## KITTITAS COUNTY COMMUNITY DEVELOPMENT SERVICES

### **RE: No 6 Rd Short Plat (SP-09-00003)**

The Kittitas County Community Development Services Department has determined that the No 6 Rd Short Plat (SP-09-00003) is a complete application and hereby grants *conditional preliminary approval* subject to the following conditions:

NO. 6 ROAD SHORT PLAT
PART OF SECTIONS 29 & 30, T. 17 N., R. 19 E., W.M.
KITTITAS COUNTY, WASHINGTON

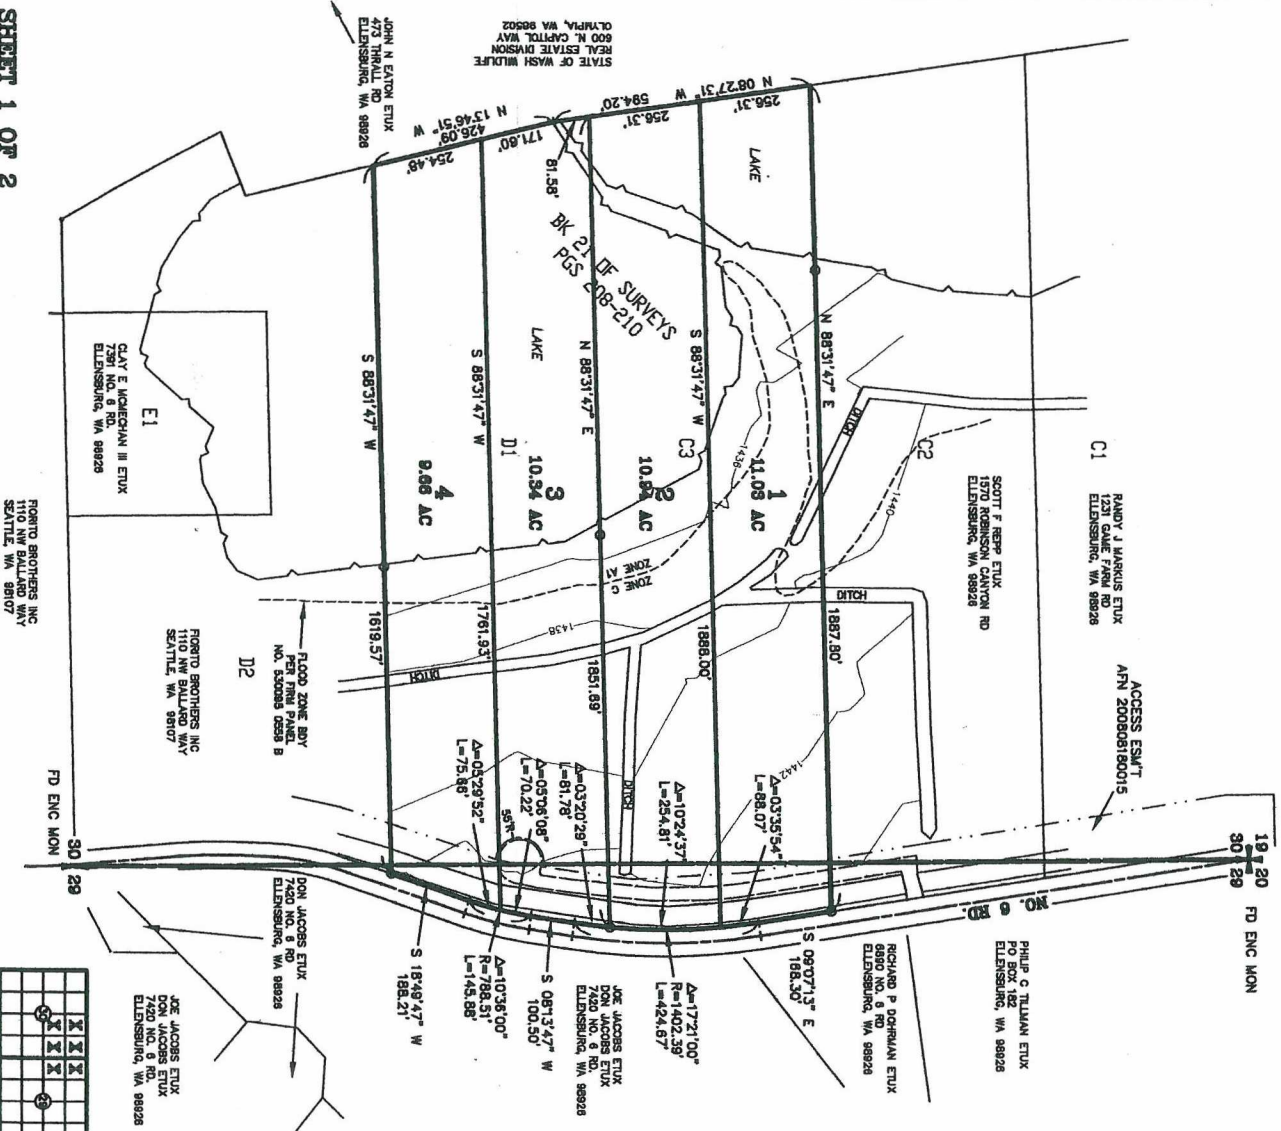
1. Both sheets of the final mylars shall reflect short plat number SP-09-00003 and an accurate legal description shall be shown on the face of the final plat.

2. Full year's taxes must be paid on all tax parcel numbers per requirement of the Kittitas County Treasurer's Office.
3. The following plat notes shall be recorded on the final mylar drawings:

- All development must comply with International Fire Code.
  - This short plat has exhausted the use of the one time split provision allowed per Kittitas County Code. No further one time splits are allowed for the subject parcels and subsequent parcels created via this short plat.

- The subject property is within or near designated natural resource land of long-term commercial significance on which a variety of commercial activities may occur that are not compatible with residential development for certain periods of limited duration. (RCW 36.70A.060(1)) Commercial natural resource activities performed in accordance with county, state and federal laws are not subject to legal action as public nuisances. (RCW 7.48.305)

- The approval of this division of land includes no guarantee that there is a legal right to withdraw groundwater within the land division. The approval of this division of land provides no guarantee that use of water under the ground water exemption (RCW 90.44.050) for this plat or any portion thereof will not be subject to curtailment by the Department of Ecology or a court of law.

- Metering shall be required on all new residential well connections and metering results shall be recorded in a manner consistent with Kittitas County and Washington State Department of Ecology requirements.

- Kittitas County will not accept private roads for maintenance as public streets or roads until such streets or roads are brought into conformance with current County Road Standards. This requirement will include the hard surface paving of any street or road surfaced originally with gravel.
